16. APPENDIX J - SCHEDULE OF DRAINAGE PLAN REVISIONS

SCHEDULE OF MINOR CHANGES TO APPROVED SURFACE WATER DRAINAGE DRAWINGS

DRAWING NO. (PROJECT CODE-ORIGINATOR-ZONE-LEVEL-TYPE-ROLE-NUMBER)  
SAL-HYD-00-ZZ-DR-C-7102

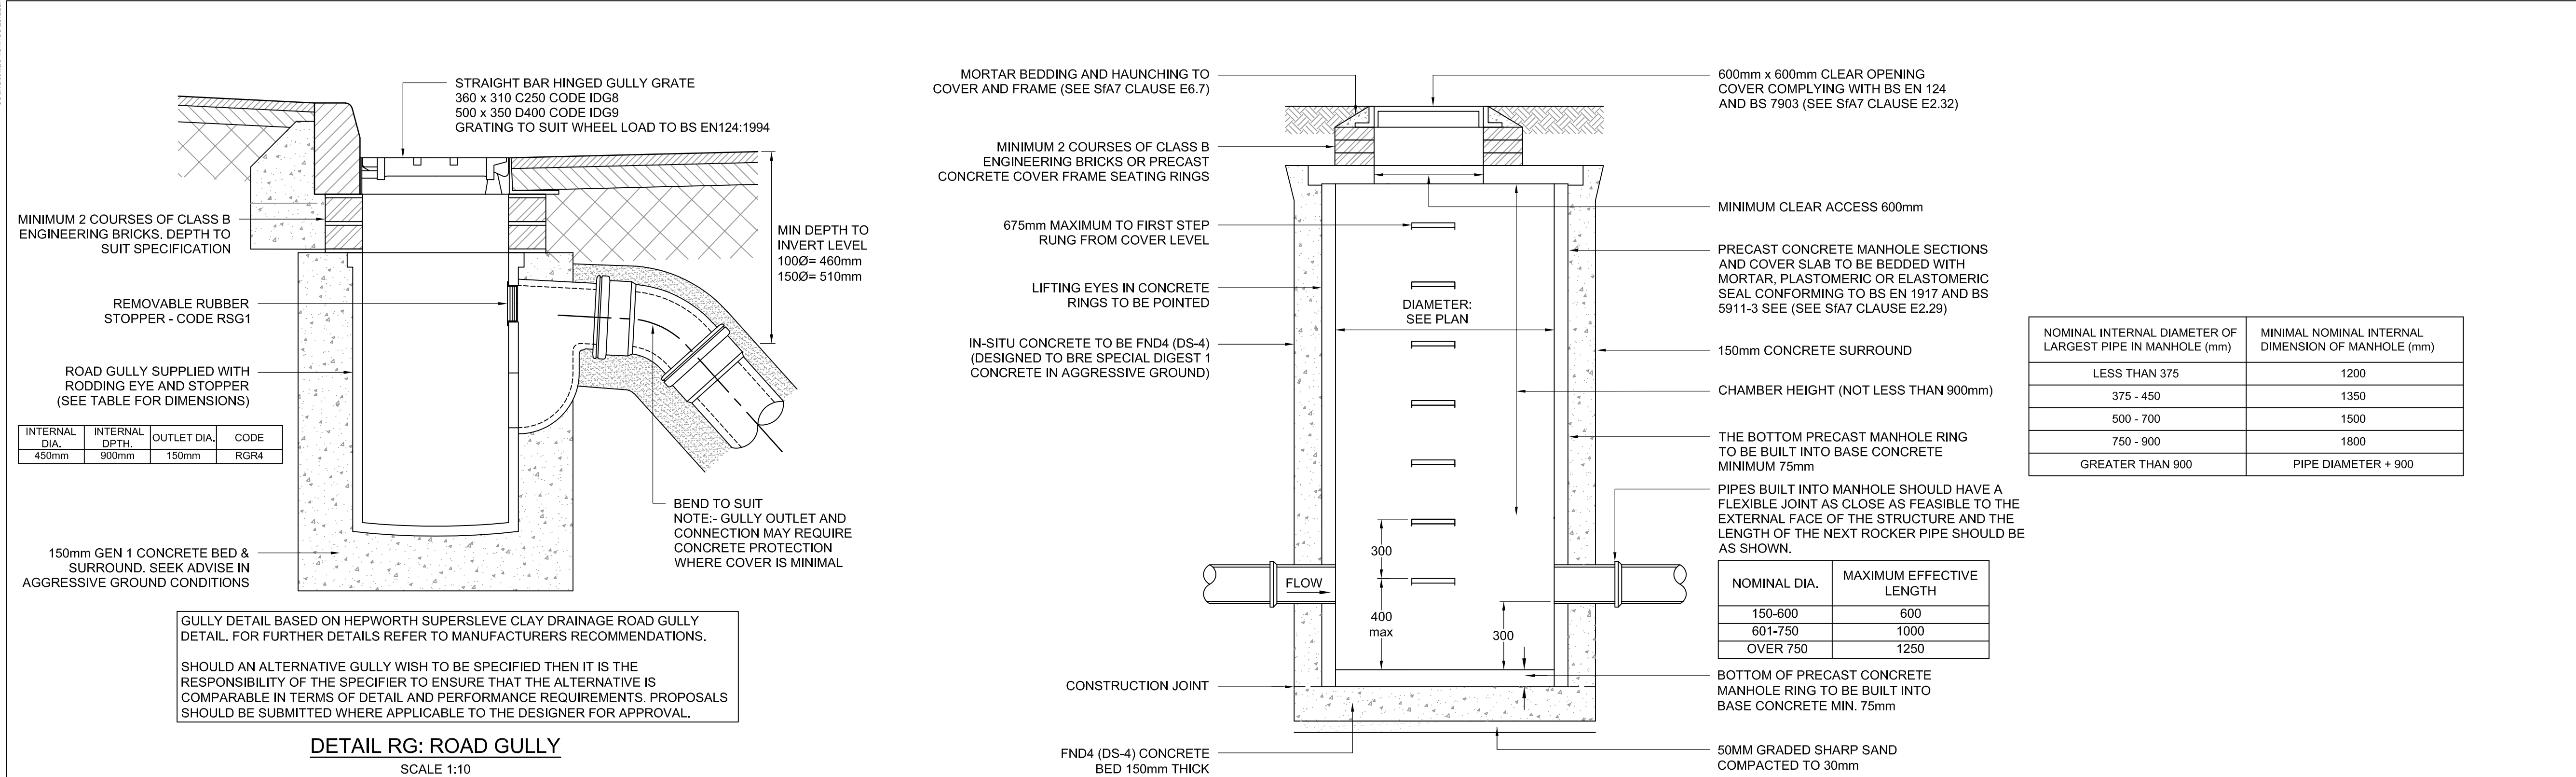
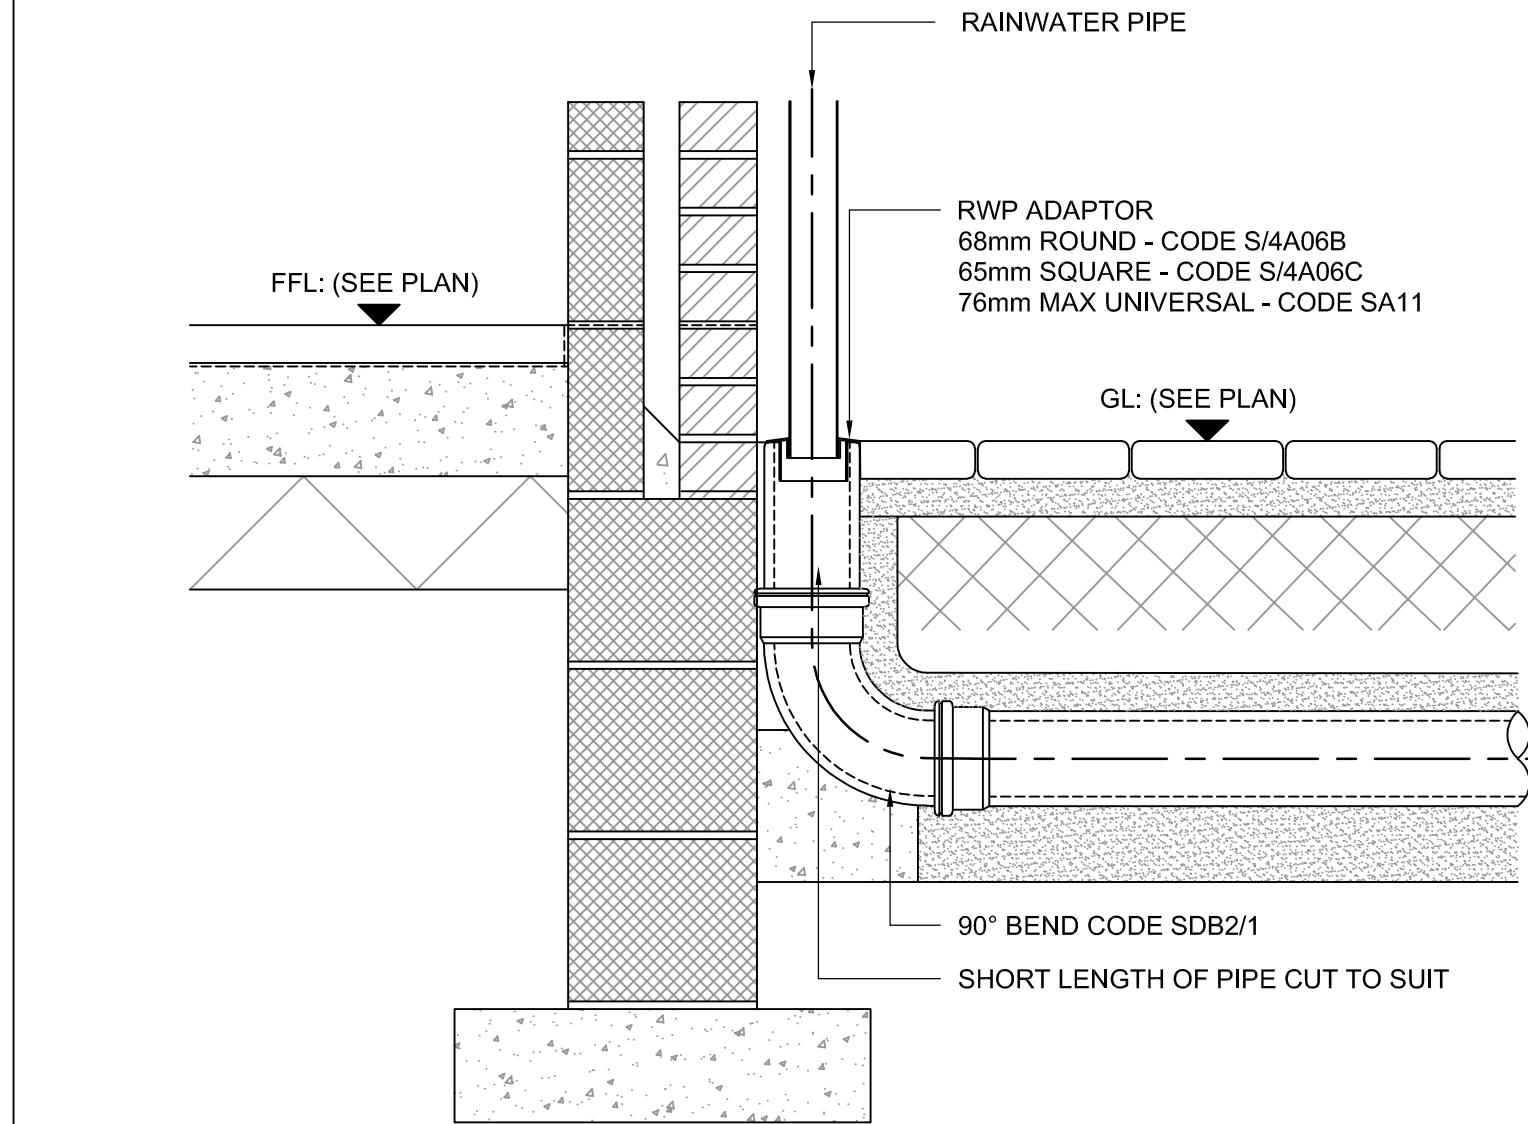
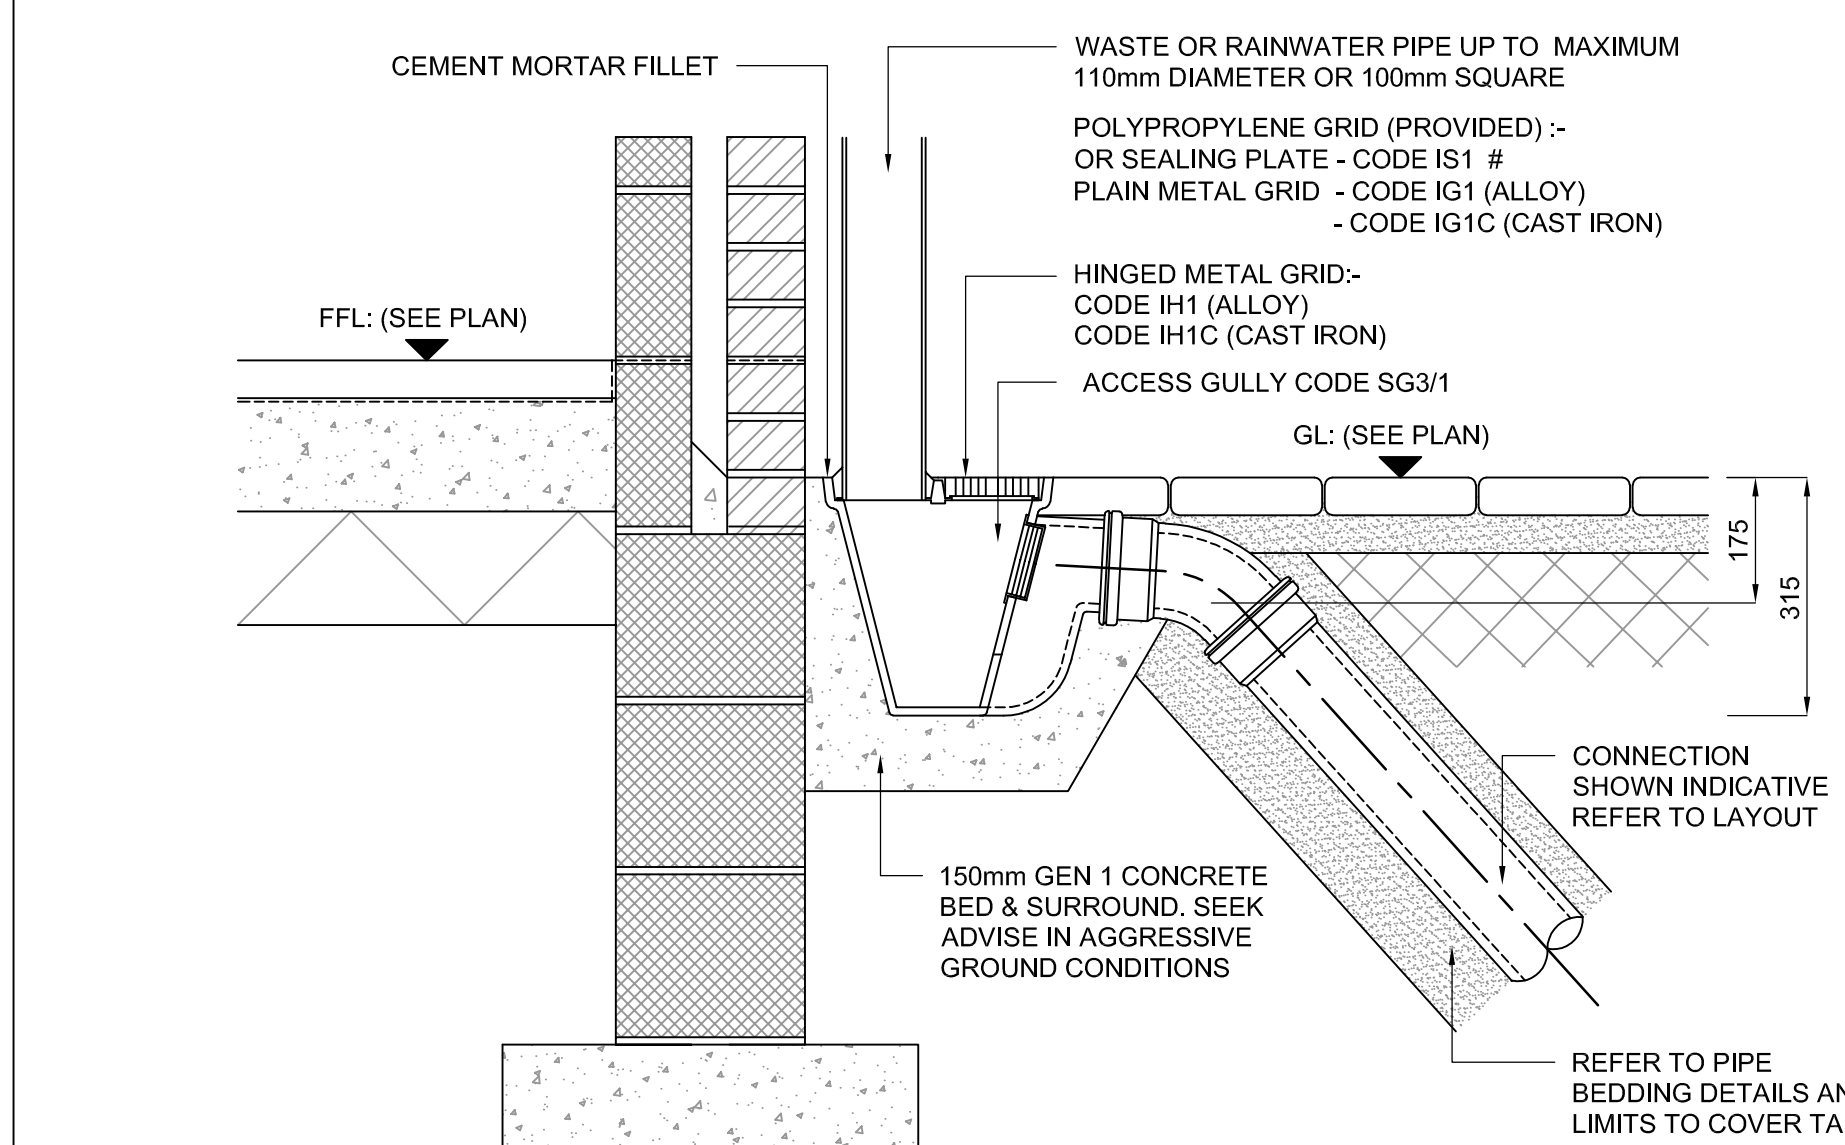
SAL-HYD-PH1-ZZ-DR-C-7102			
Rev P05	ARUN Approved Issue.		
Rev C01	Construction Issue *no changes*		
Rev C02	As built Issue *no changes*		
Rev C03	H&S Issue - title block changed	title block changed	Error corrected
Rev C04	As built Issue - title block changed	title block changed	Changed back to As-built
SAL-HYD-PH1-ZZ-DR-C-7103			
Rev P09	ARUN Approved Issue.		
Rev C01	Construction Issue *no changes*		
Rev C02	H&S Issue - title block changed	title block changed	Error corrected
Rev C03	As built Issue - title block changed	title block changed	Changed back to As-built
SAL-HYD-PH1-ZZ-DR-C-7104			
Rev P10	ARUN Approved Issue.		
Rev C01	Construction Issue *no changes*		
Rev C02	Note added. GW and manhole sump added	Note added. GW and sump added	Additional information. Sump required in MH's
Rev C03	H&S Issue - title block changed	title block changed	Error corrected
Rev C04	As built Issue - title block changed	title block changed	Changed back to As-built
